Application Reference:- M/123/17/HH

Two storey extension to existing building.

Little Thatch, 93 Middleton Road, Middleton on Sea PO22 6DW

GROUND FLOOR PLAN

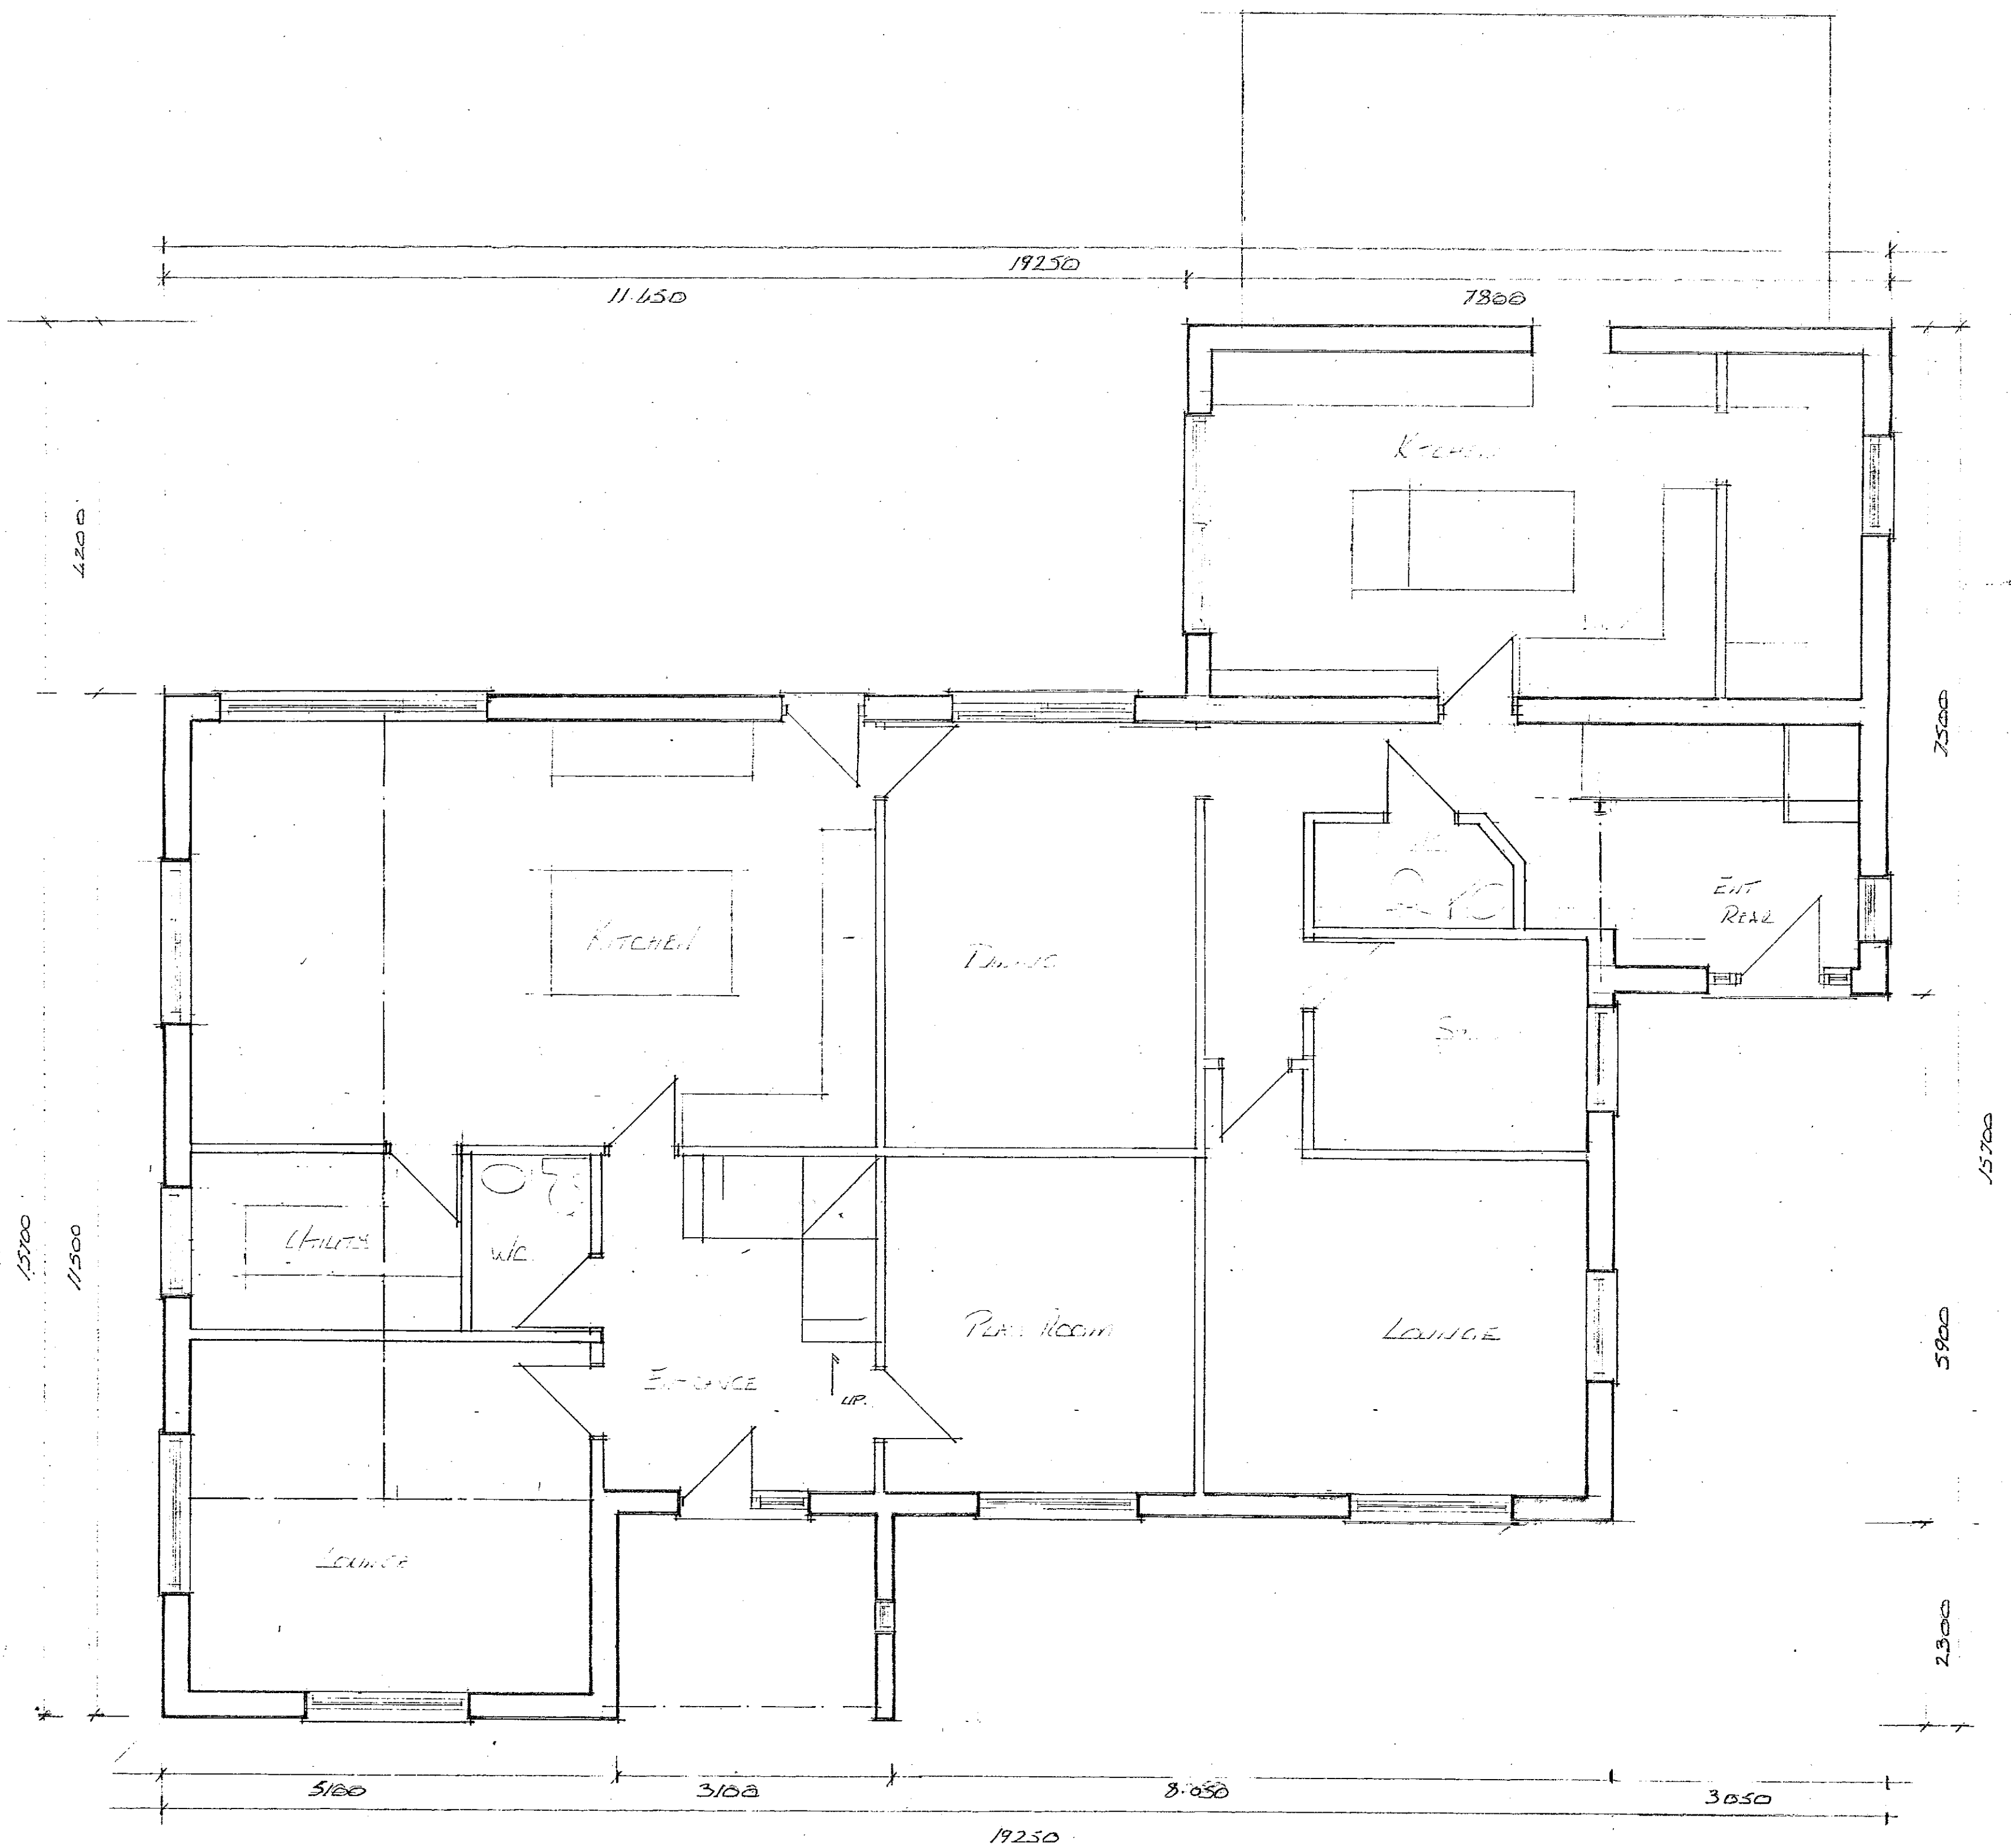
The description does also not mention the incorporation of a formal and substantially sized annexe on the eastern side, next to us. Bedroom 4 and its en-suite would not be physically connected to the rest of the first floor and the duplication of entrance doors, kitchens, lounges and downstairs wcs highlights the intensive use of the extended building. In fact, the proposed layout would provide accommodation which would be totally independent from the main dwelling. The second kitchen area would be sufficiently large to accommodate a range of appliances and there would be no need for the occupants to enter the host dwelling for laundry or meals etc. There is no demonstrable dependence on the western side of the dwelling in terms of functional and practical links.

Following on from the above, the plans do not include a scale bar or a paper size and so it is impossible to properly compare the existing and proposed floorplans and elevations. Whilst the agent has chosen to add some dimension figures to the proposed floorplans there are none on the existing floorplans or the elevations (existing or proposed).

We would also like to highlight that the rear doors on the orangery don't seem to tie up when looking at the rear elevation drawing and the ground floor plan.

EAST ELEVATION

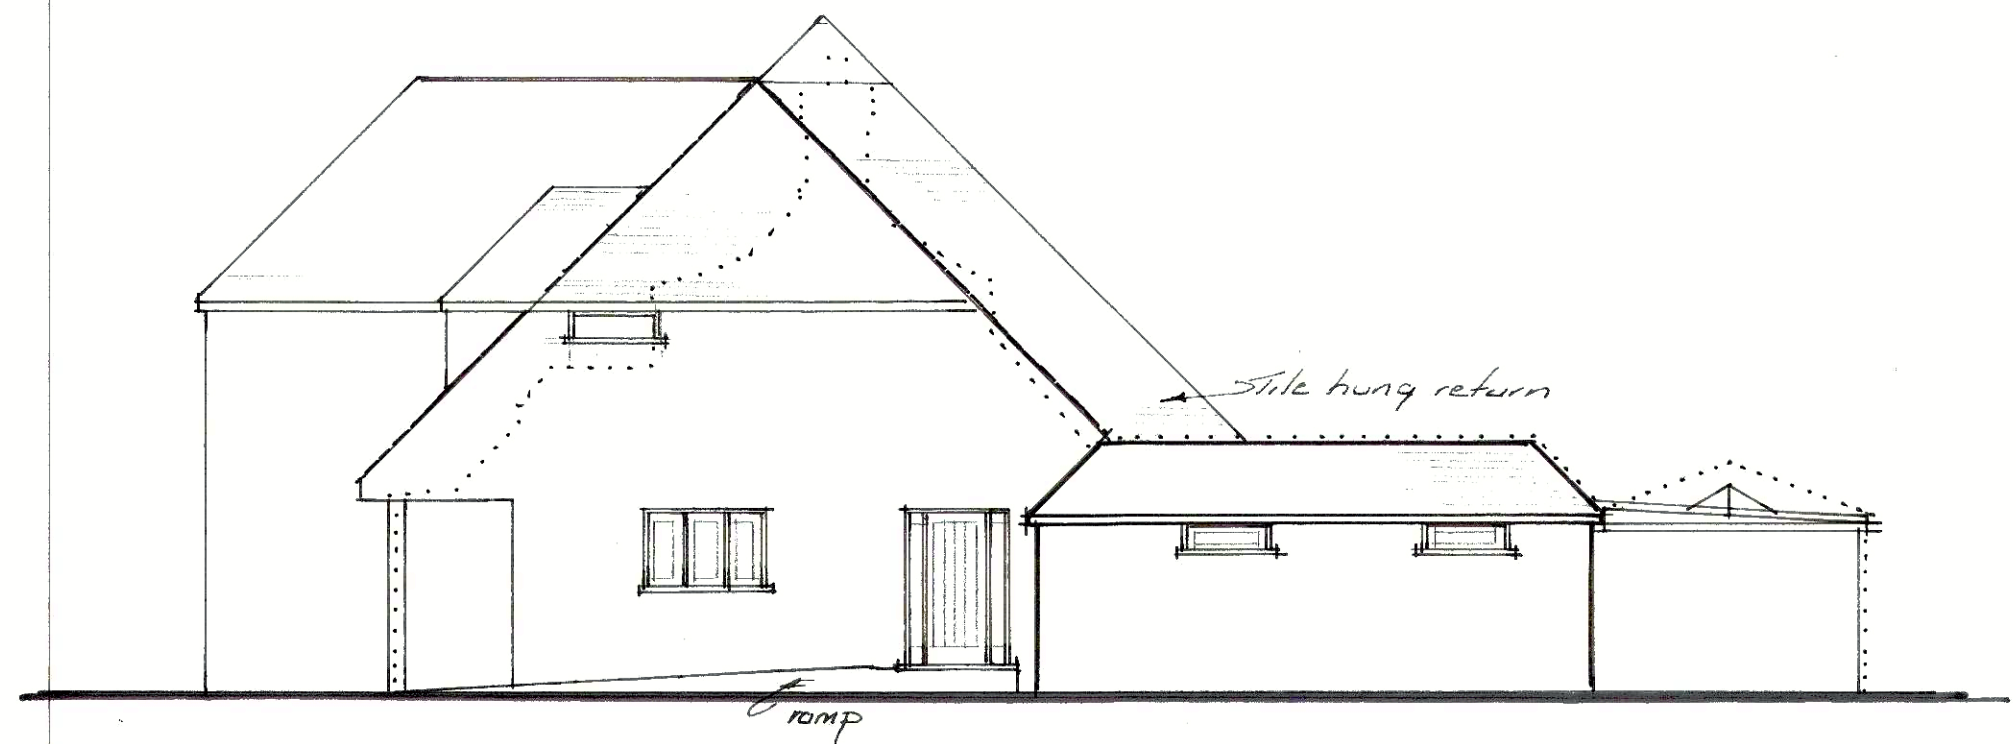
Focusing on the elevation facing our property, the configuration of the roof would look bulky and particularly awkward. The substantial increase in the height of the side elevation, as well as the eaves and ridgeline of the roof itself, would be particularly dominating. The two-storey house that would be created would have an over-bearing presence on us, resulting in a loss of outlook and light levels, particularly at the rear of property, especially in the afternoon during the months when the sun is lower in the sky.

Currently there are only ground floor windows facing us at no. 93, hidden behind the fence (which is not acknowledged in Section 15 of the Application Form). The proposal includes three more windows above on the upper levels. The two rooflights would serve Bedroom 4 and the stairway area leading to it. Neither of these appear to be necessary and we consider them to be un-neighbourly. The window serving the un-named room (which could be a walk-in wardrobe or study area etc) is also un-neighbourly and adds to the presence of being continually overlooked. We are also concerned that an alternative internal layout (which wouldn't be subject to Planning permission) could exacerbate the loss of privacy in the future.
